**ADC Planning Consultation
Response from the Historic Buildings Adviser**

Application Number	Y/57/13/L & Y/56/13/
Address	Berricourt, Main Road, Yapton, BN18 0ED
Description	Application for Listed Building Consent for replacement of existing defective floor joists at second floor level, Pitched and Flat Roof to existing Listed Building with new access gate from Main Road.
Case Officer	Simon Davis
Site Visit

Existing Second Floor Plan @ 1:50

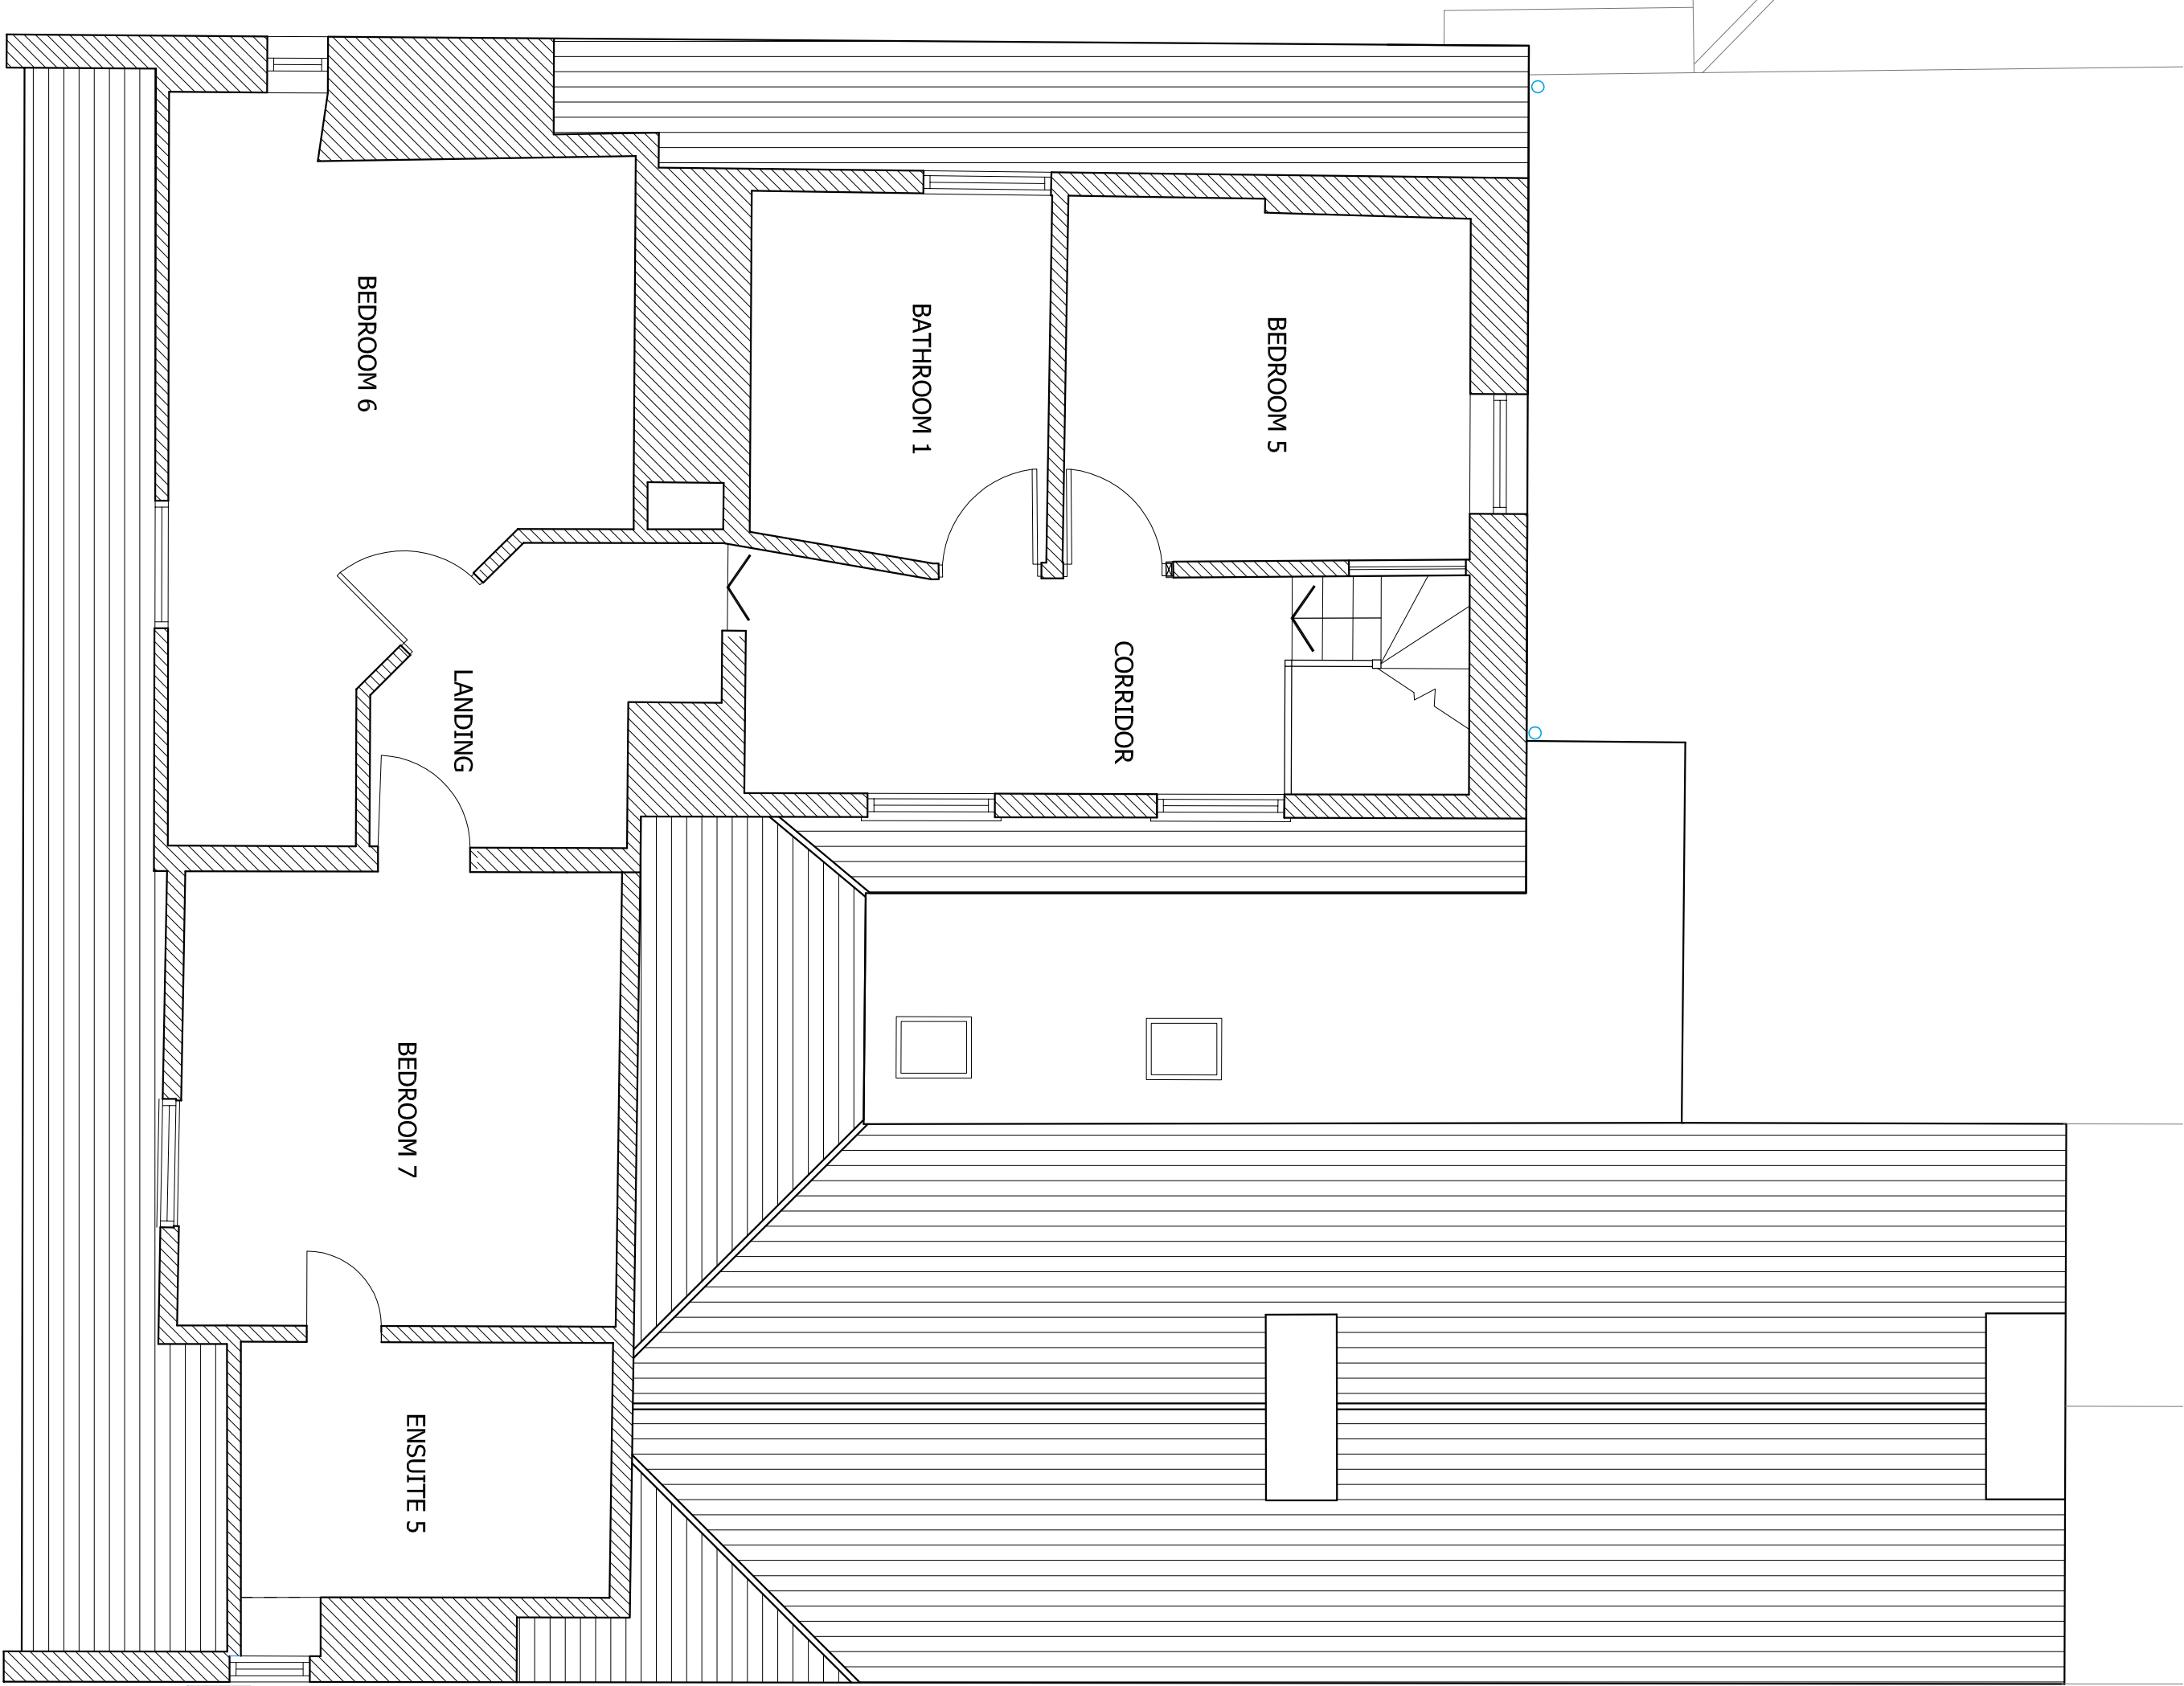
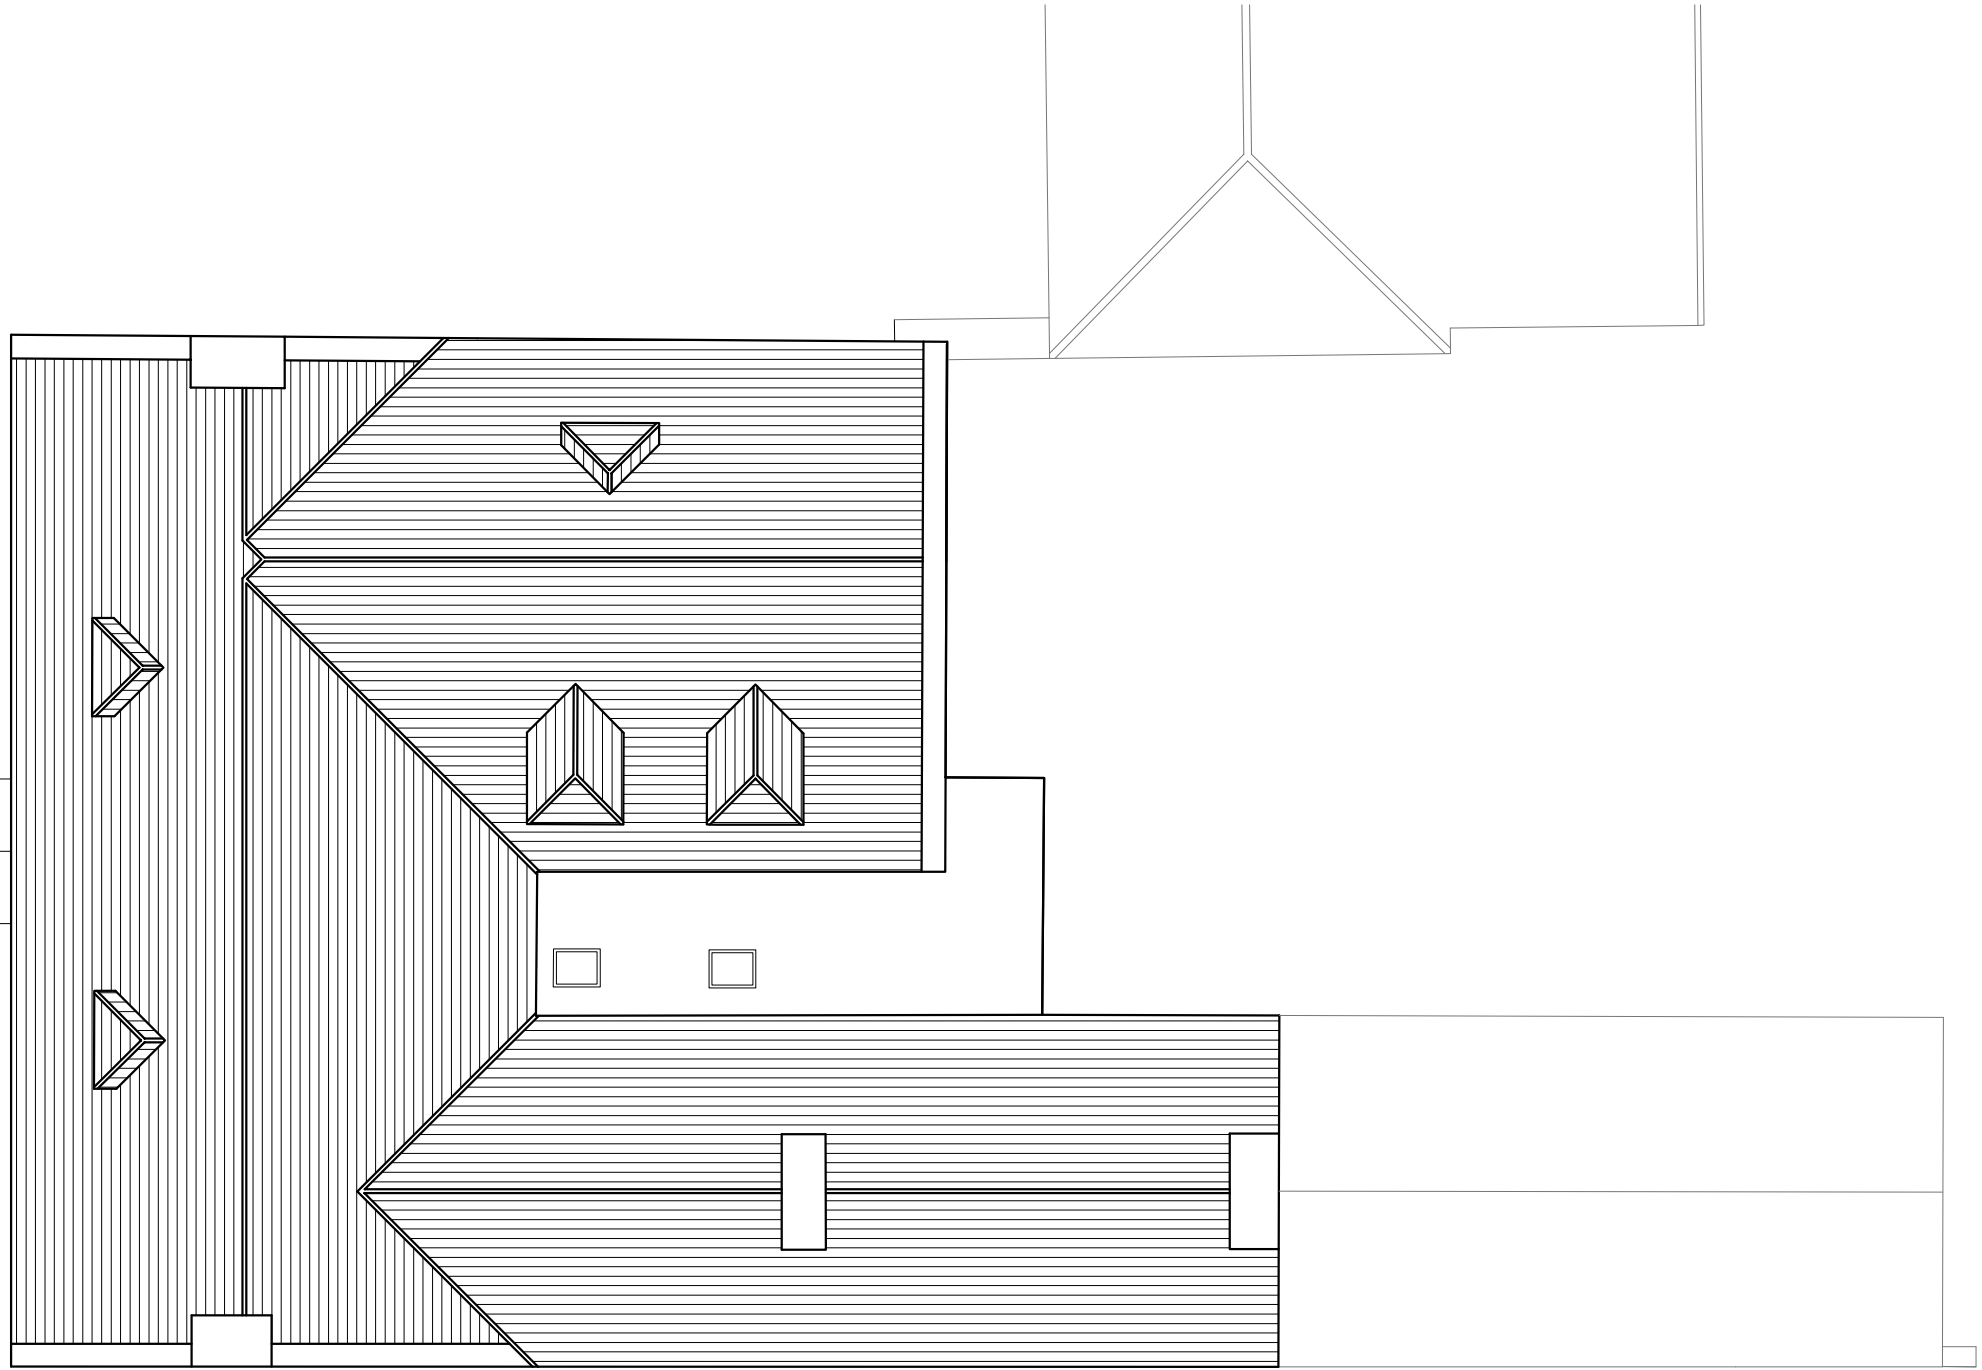
This scheme proposes replacement of the roof structure and much of the second floor structure resulting in excessive loss of fabric and major intervention into the listed building. This is not acceptable particularly given the lack of structural qualification or evidence of need for such alterations.

Historic structural members should always be retained in-situ wherever possible and repaired or reinforced with new. Their replacement should not be supported where this is achievable. A further concern with this approach is the amount of adjacent and related fabric which would have to be disturbed – walls, flooring, etc and the impact this will have on the character of the historic interior. This is significant and would lead to excessive loss of historic interest. Historic fabric is a finite resource and should be retained wherever possible. English Heritage guidance is quite clear on this:

Proposed Gated Plan Entrance @ 1:100

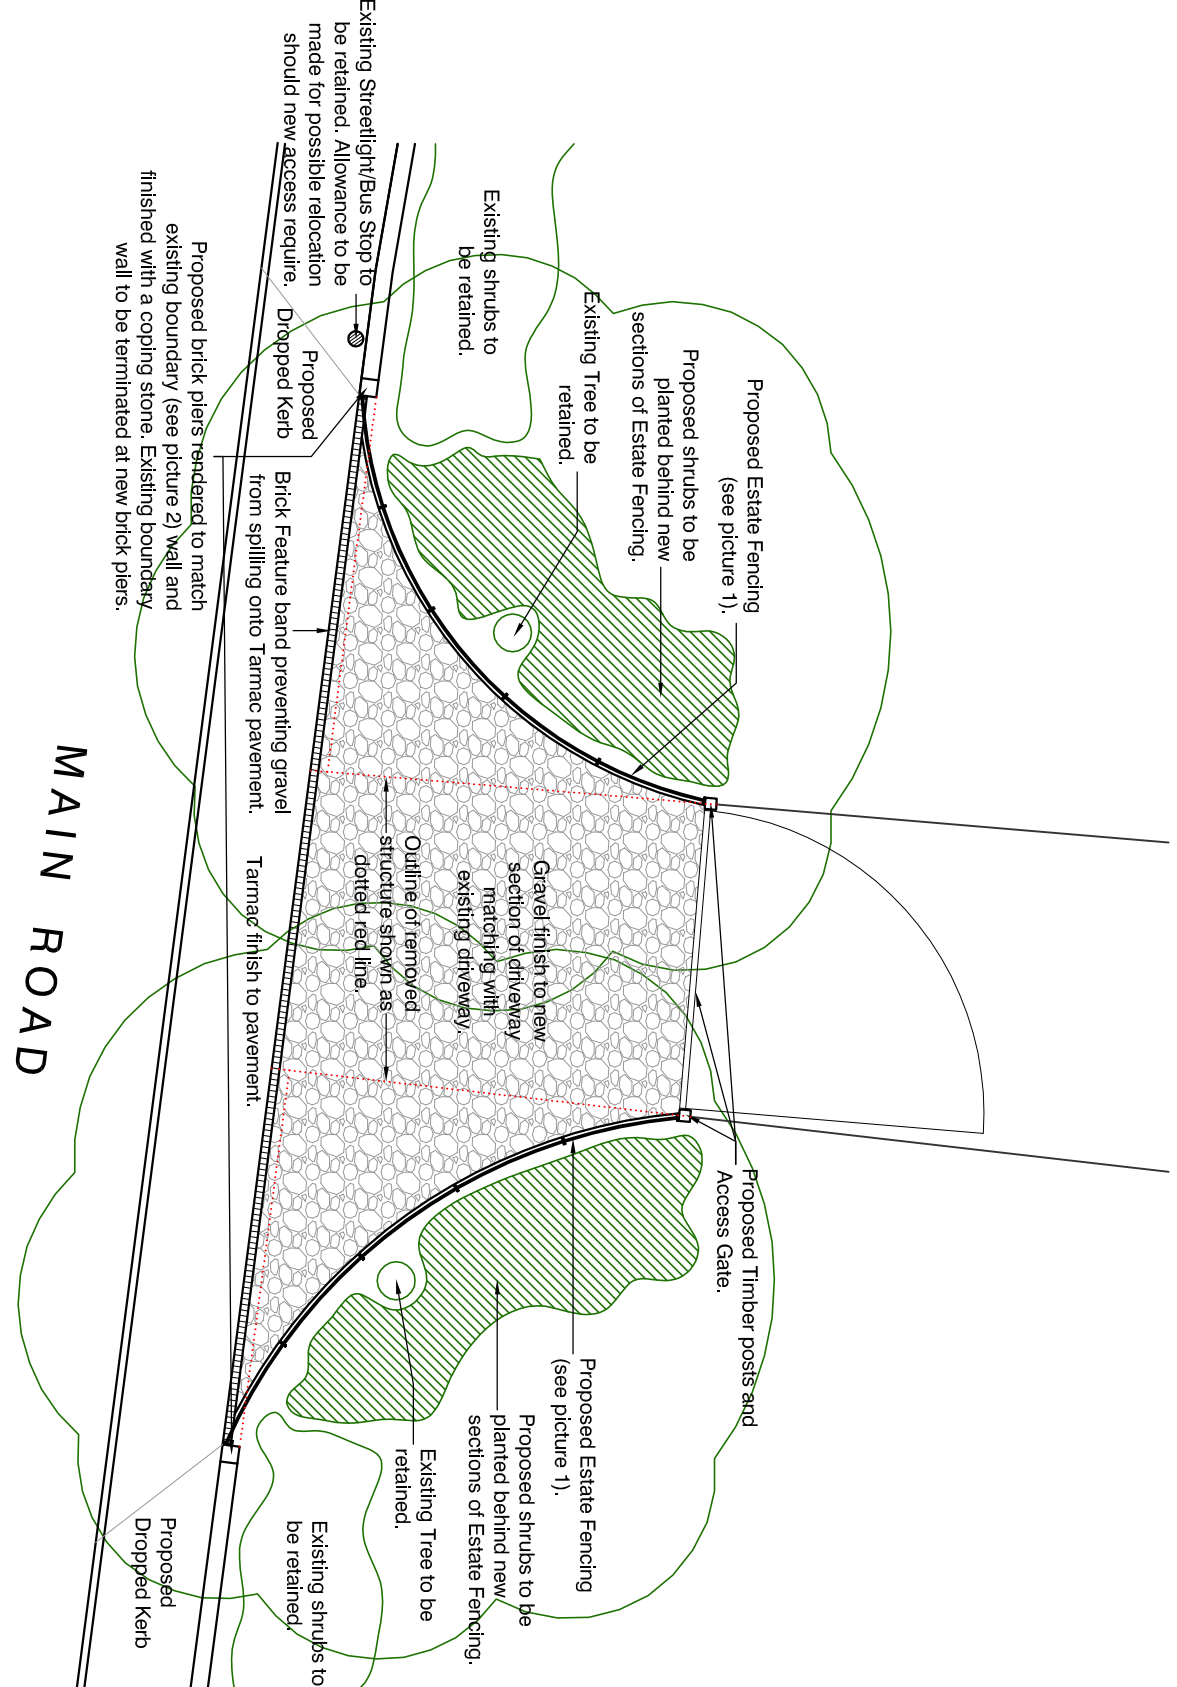
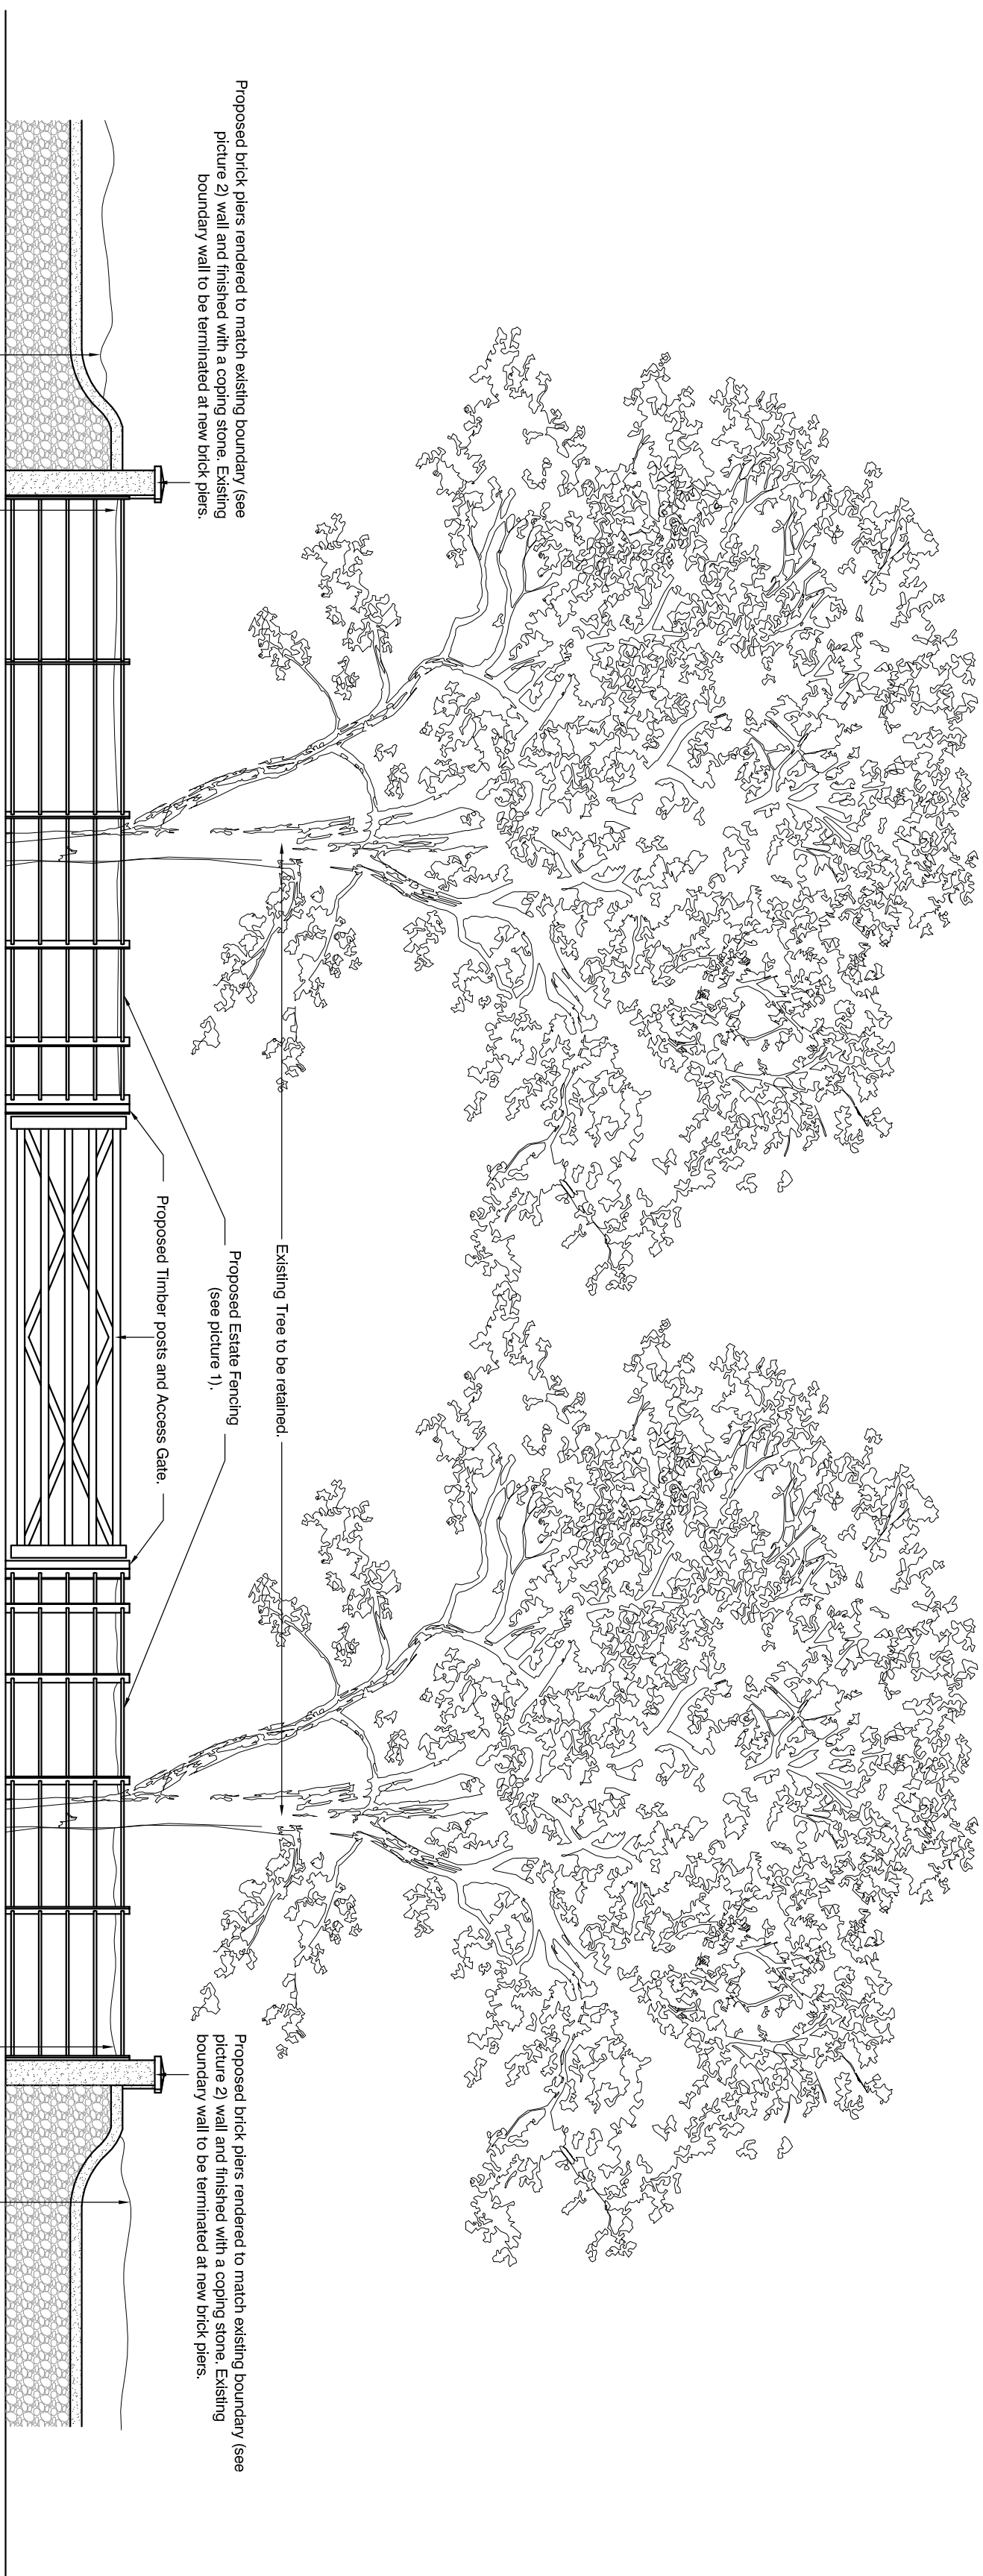
A further concern with this scheme is the proposed treatment of the entrance which again appears excessive and results in excessive loss of flint walling. This should be reduced to retain more of the boundary wall.
